**Section 96A of the Town & Country Planning Act 1990 (as amended)
Town and Country Planning (Development Management Procedure) (England) Order 2015
(as amended) - Article 10**

Non-material amendment following grant of A/219/17/PL to:-

Land East of Mayflower Way Windy Ridge Angmering BN16 4AY

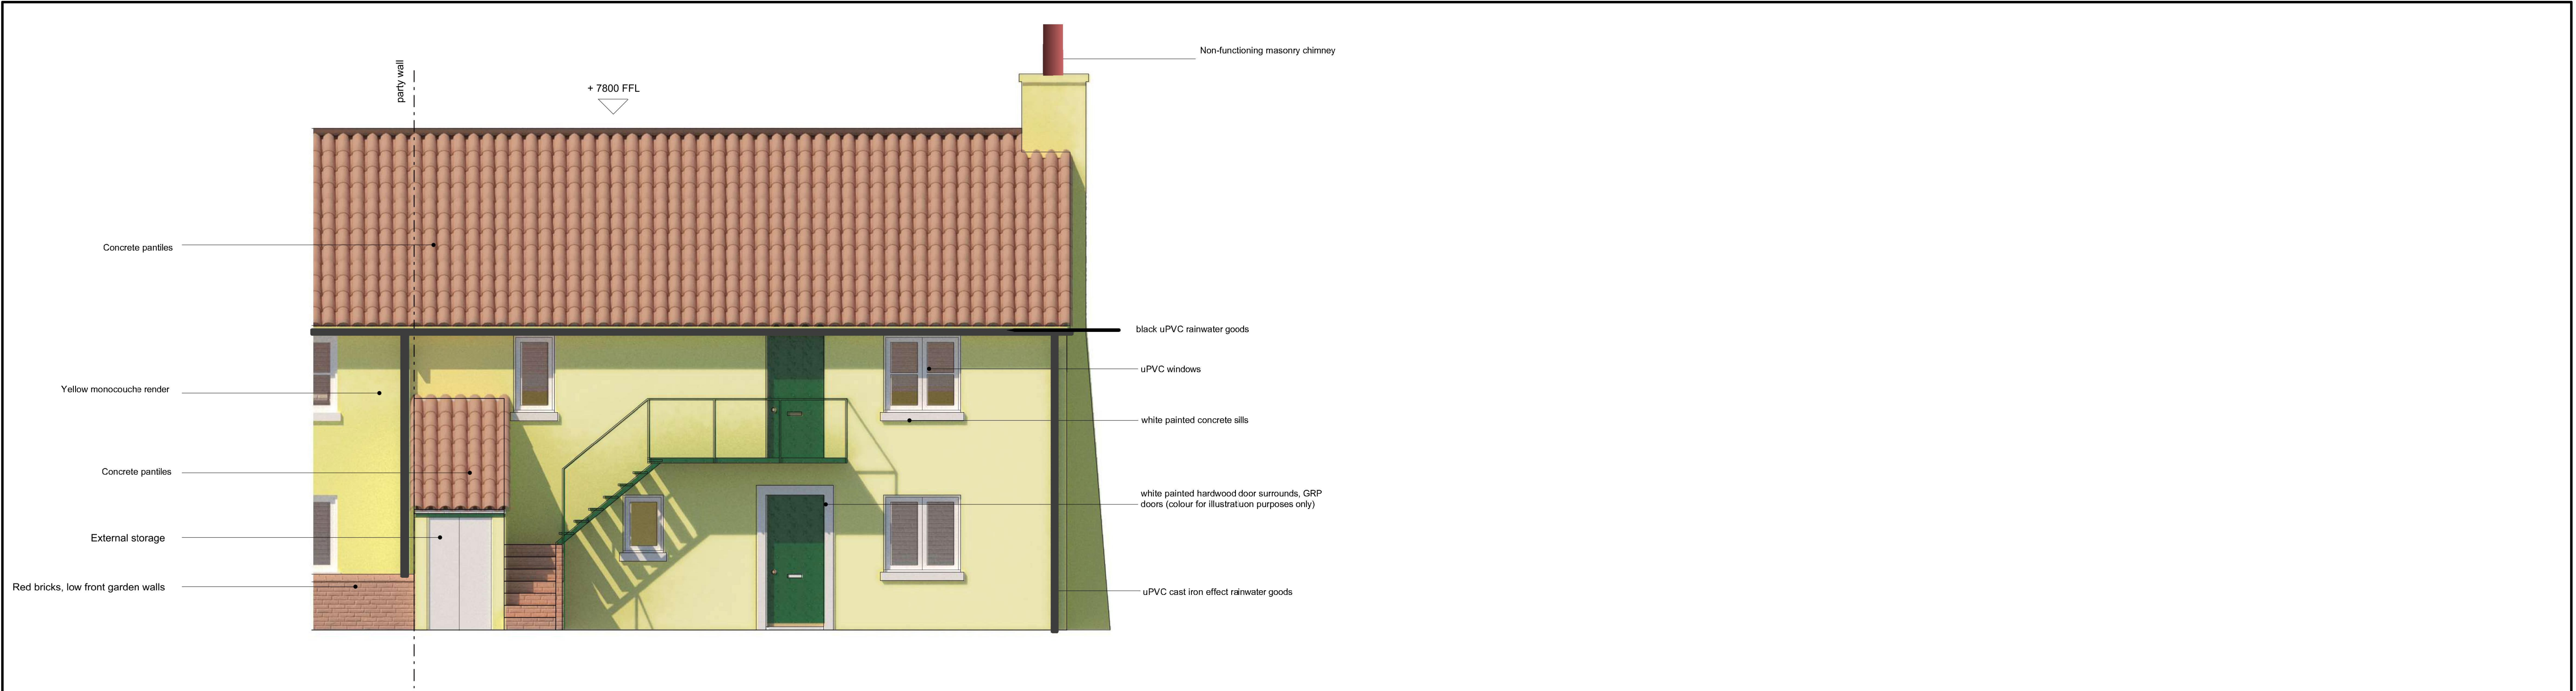
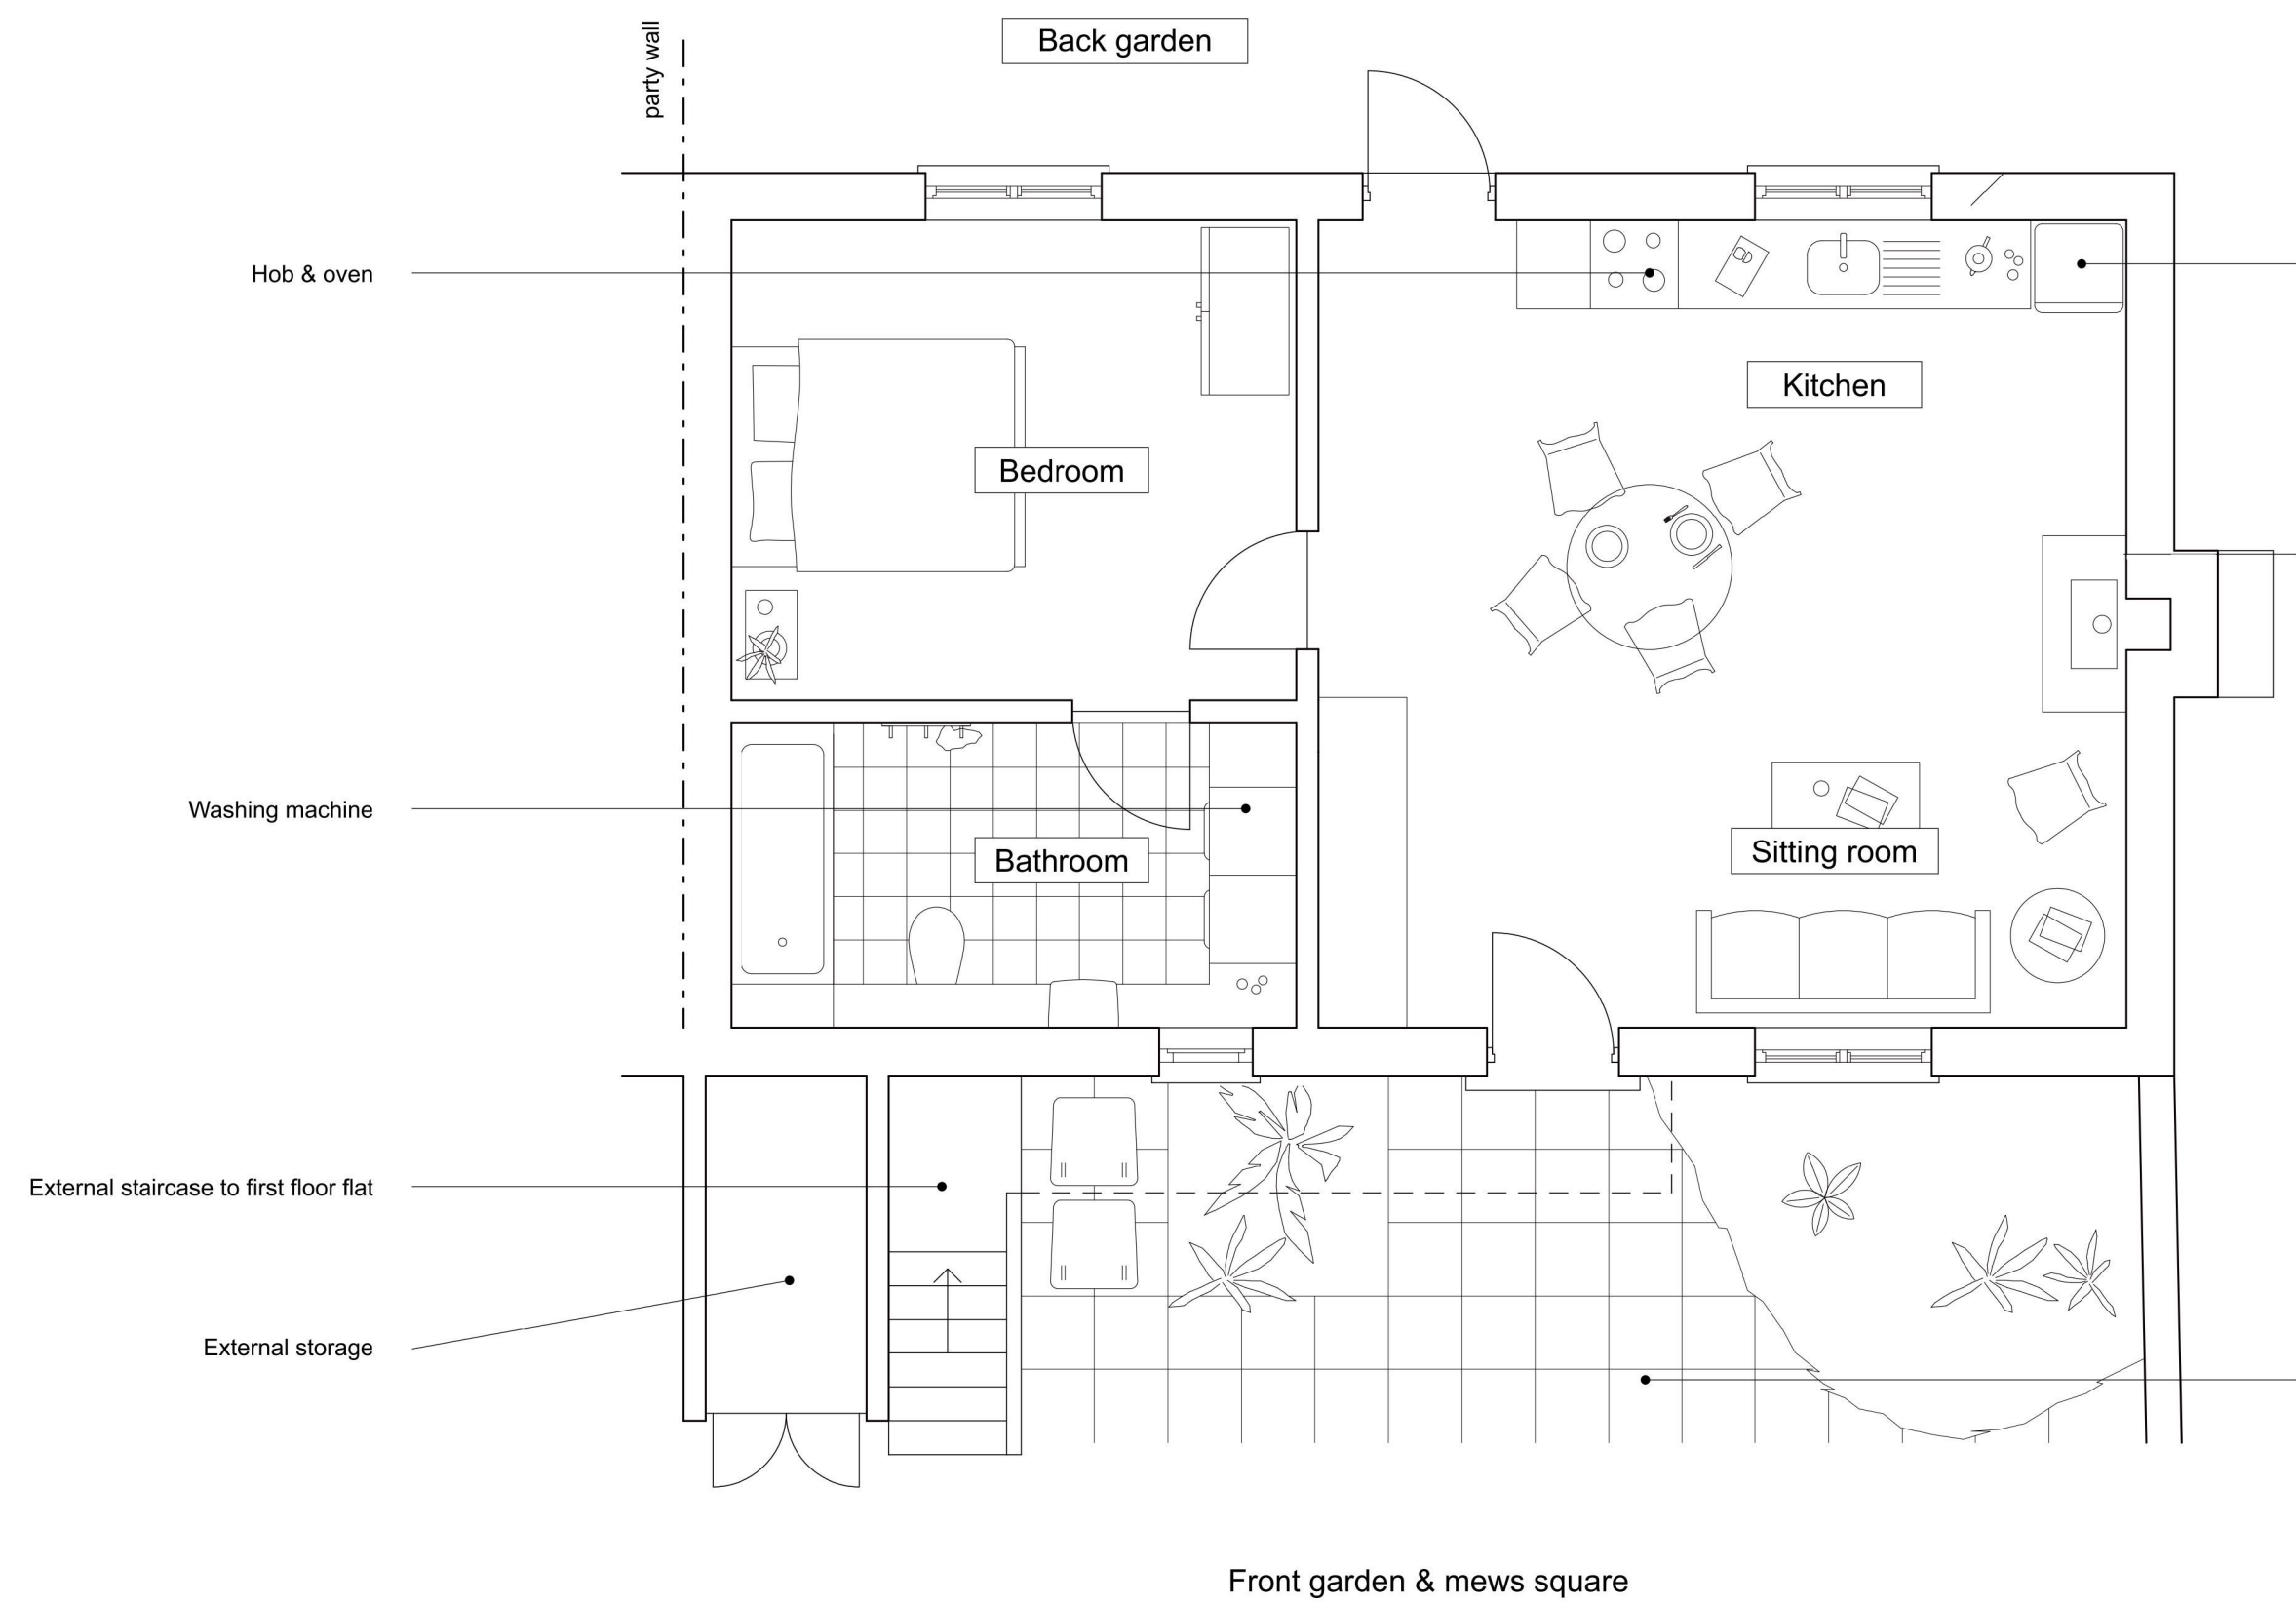
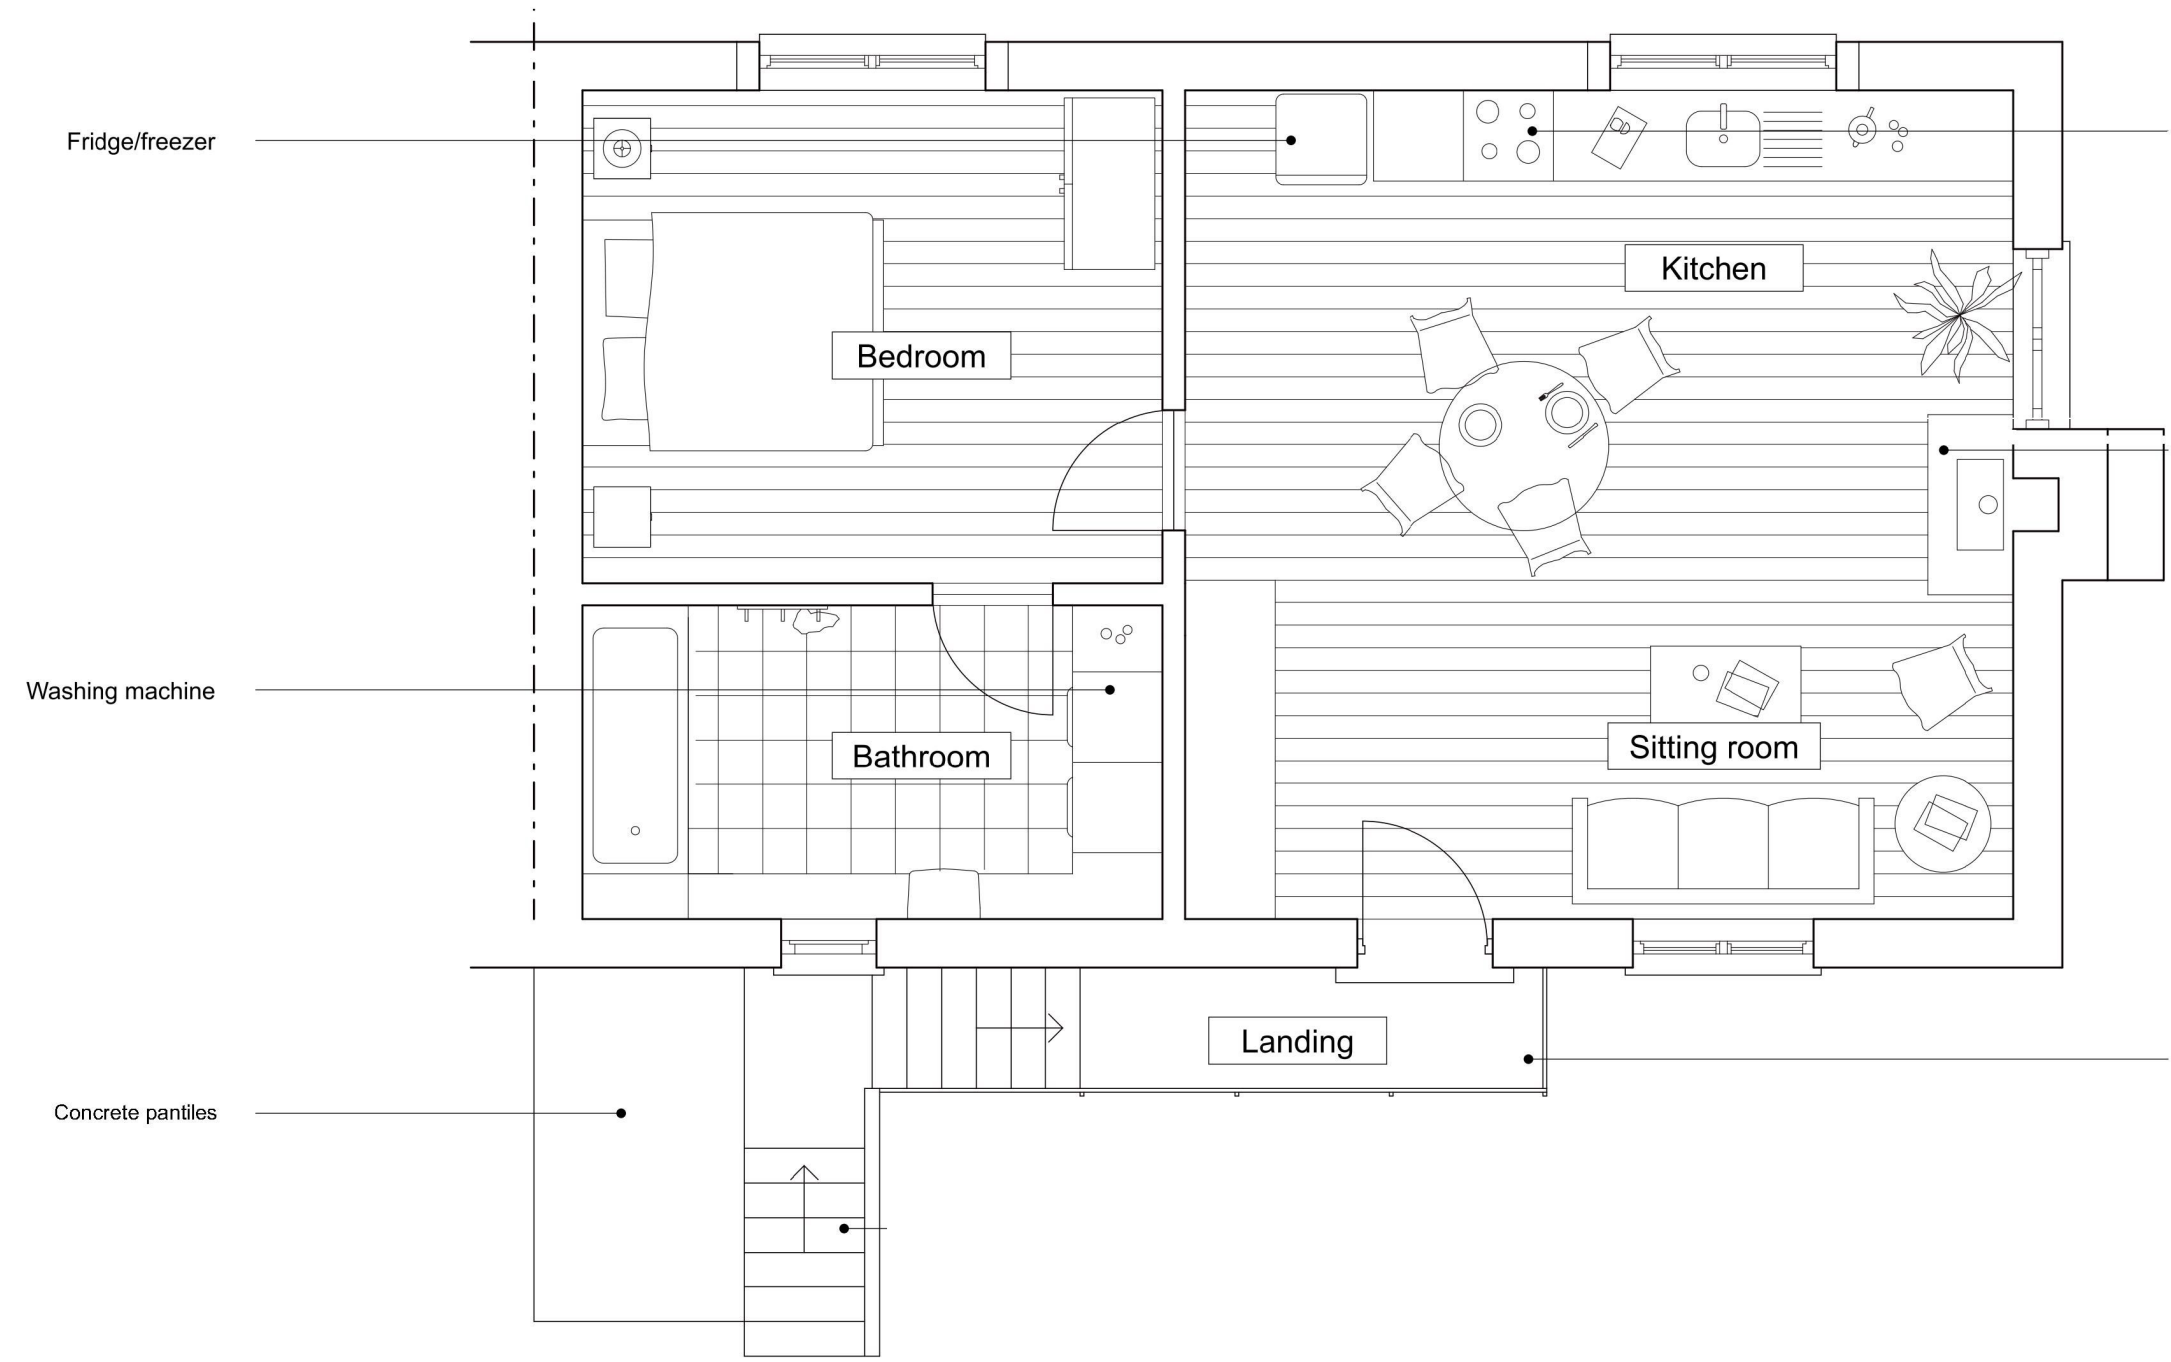
1 - to remove the galvanised steel flues however all chimneys will remain but non-functional, with traditional masonry flues (pots), 2 - roof tiles shown as clay pantiles will be changed to concrete pantiles while providing the same overall appearance, 3 - roof tiles to be artificial Slate providing the same overall appearance, 4 - rainwater goods to be black PVCu with cast Iron effect, 5 - windows to be PVCu white providing the same overall appearance, 6 - front doors to be GRP composite PAS24 while providing the same overall appearance, 7 - Lintol treatment amended where noted on drawings: RSJ detail changed in favour of homogenous brickwork, & window lintol treatment amended as noted,

17.319-P01 Rev A Terrace A Floor Plans and Elevations
17.319-P02 Rev A Terrace B Floor Plans and Elevations
17.319-P03 Rev A Terrace C Floor Plans and Elevations
17.319-P04 Rev A Terrace B 2 Bed Detail Floor Plans and Elevations
17.319-P05 Rev A Terrace B 3 Bed Detail Floor Plans and Elevations
17.319-P06 Rev A Terrace A 1 Bed Detail Floor Plans and Elevations
17.319-P07 Rev A Terrace C Flats Detail Floor Plans and Elevations
